# PLANNING AMENDMENT

| <b>SITE ADDRESS DETAILS</b><br>REAR OF 29 STATION ROAD, TIDD GOTE, NR. WISBECH                                 |  |                                                                      |  |
| <b>CURRENT APPLICATION NO:</b><br>This amendment cannot be considered unless the relevant reference is stated. |  | H21/1136/23                                                          |  |

| <b>FULL DESCRIPTION OF DEVELOPMENT OF CURRENT APPLICATION THAT THIS AMENDMENT RELATES TO</b>                                                                                             | PROPOSED HOLIDAY LODGES & YOGA BUILDING                                                                                                |  |  |

SITE PLAN 1:500

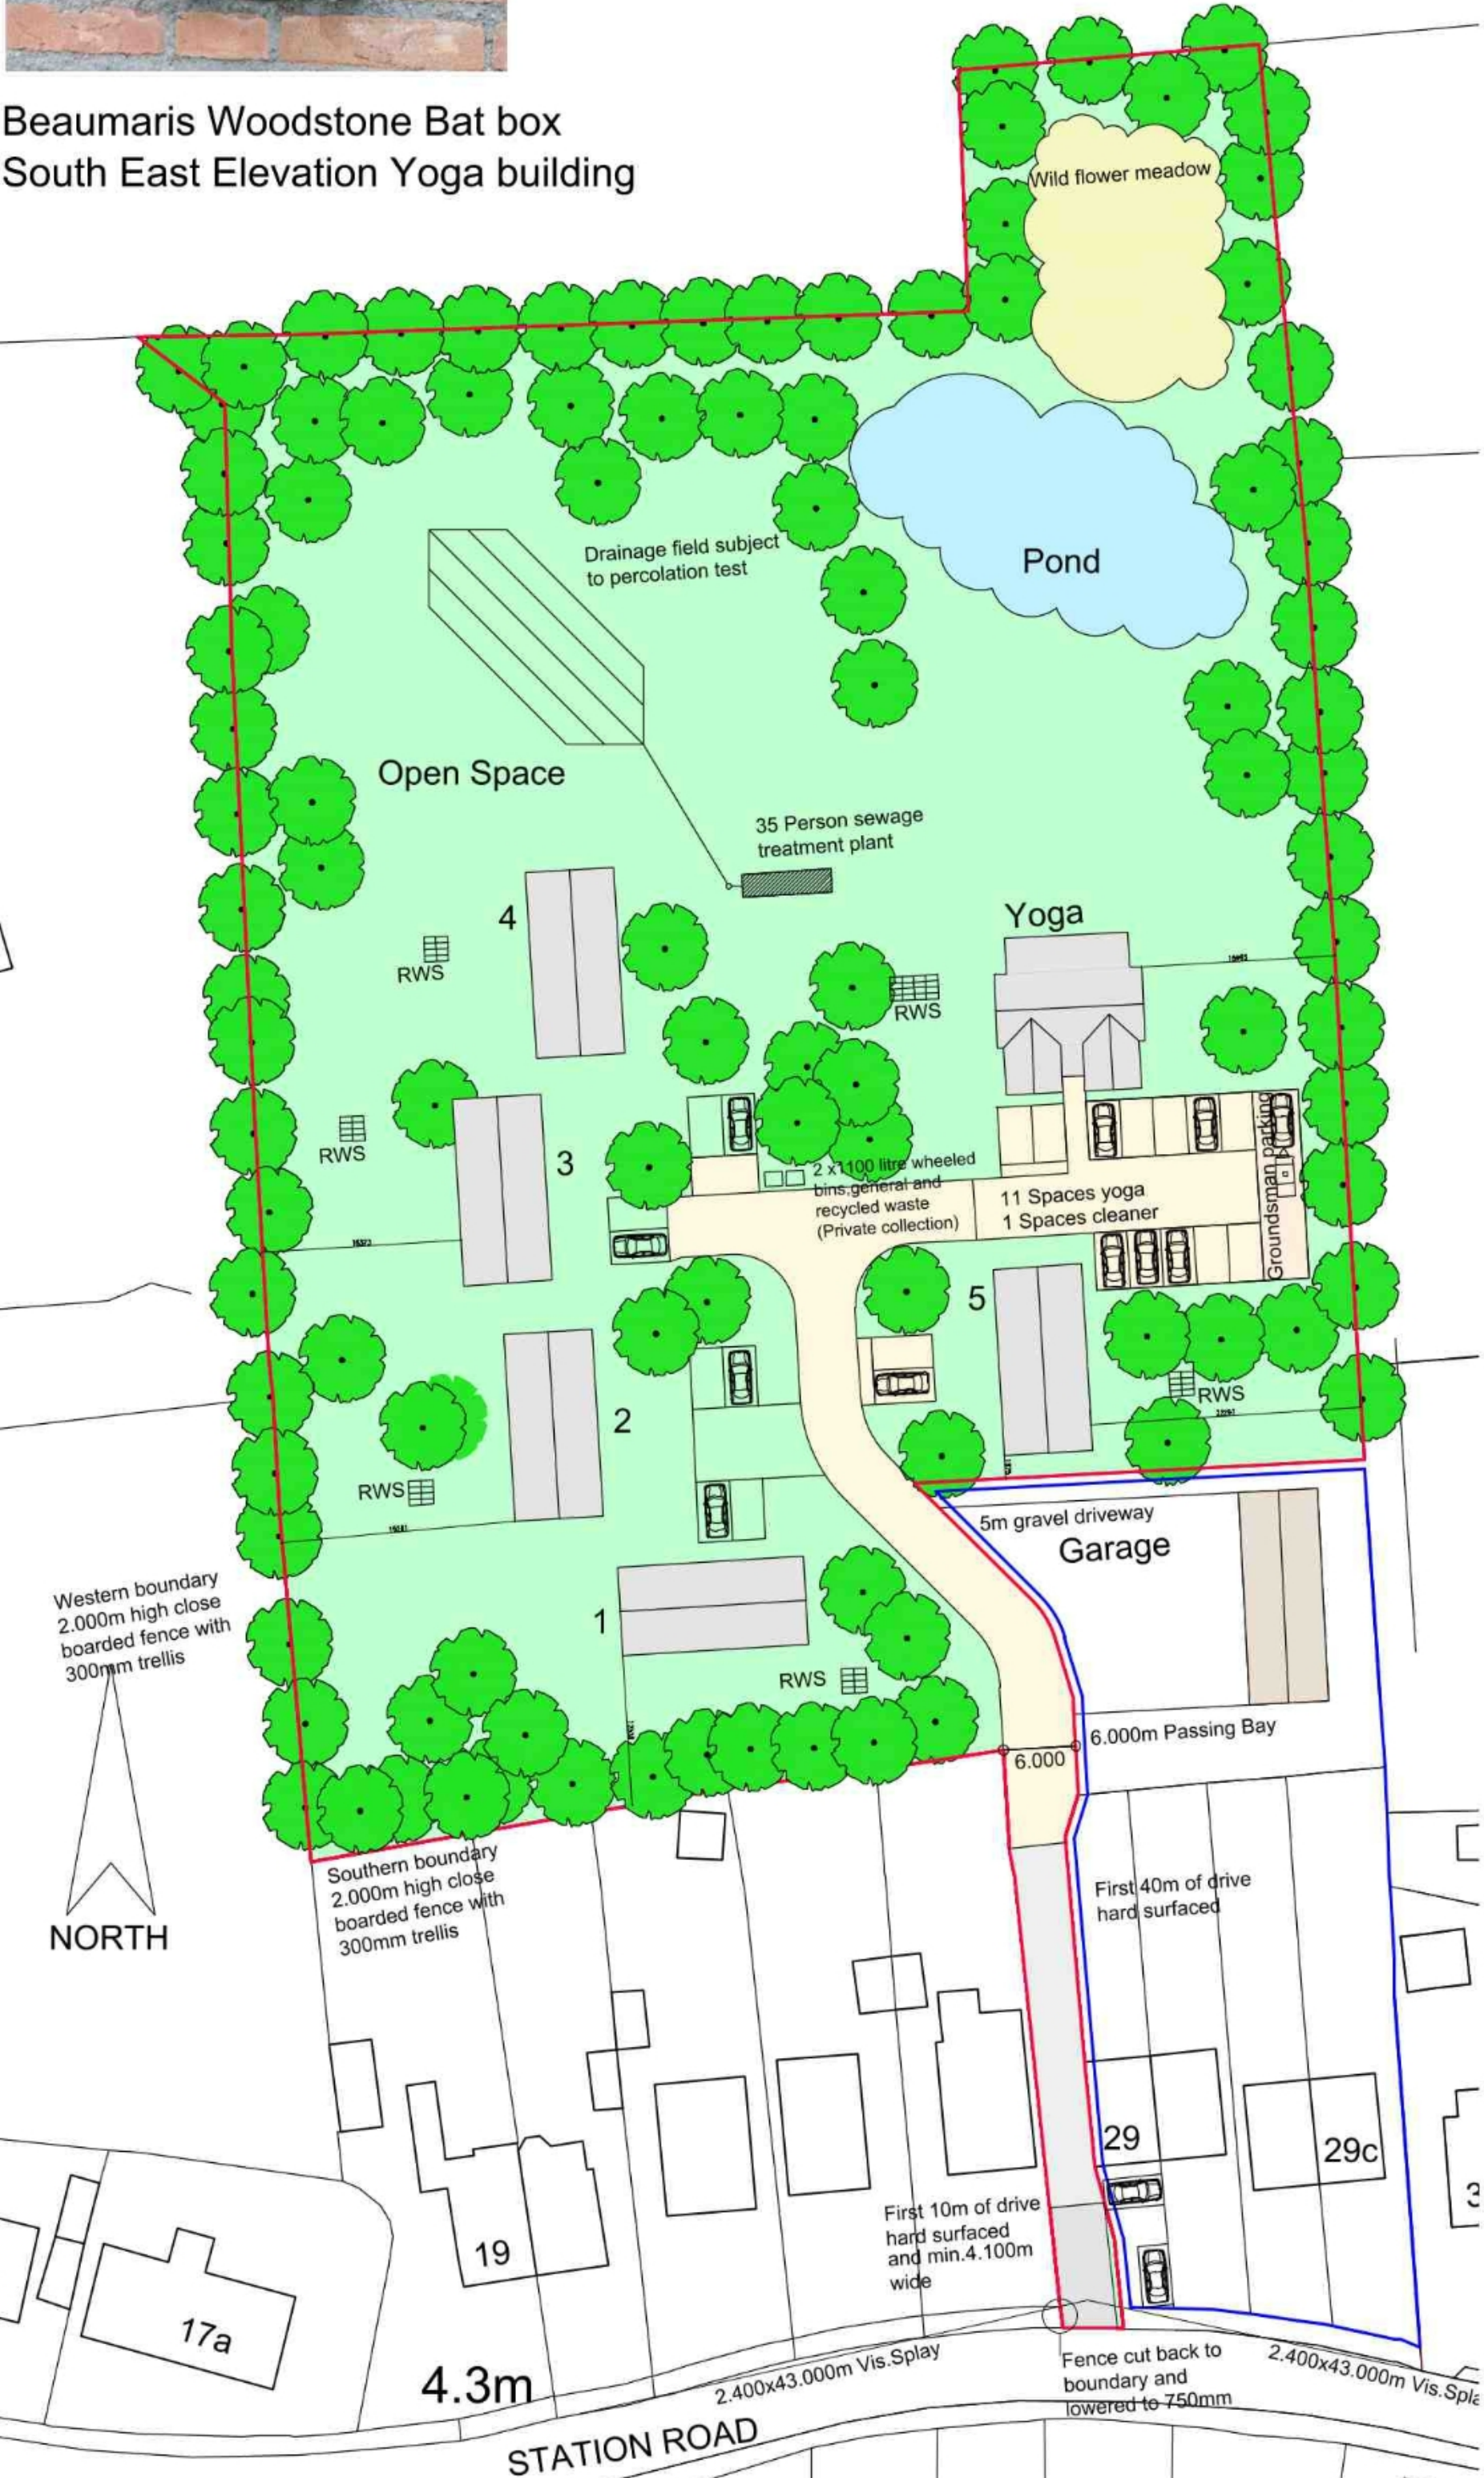
| State details of amendments proposed. (Give a full detailed list of the changes; and also mark these clearly on the accompanying plans. Only the changes listed here will be considered) | UNITS 1,2,3 MOVED AS REQUESTED<br>VISIBILITY SPLAY ADDED, DRIVE<br>AMENDED PERIMETER FENCE<br>ADDED & TRANSPORT STATEMENT<br>SUBMITTED |  |  |
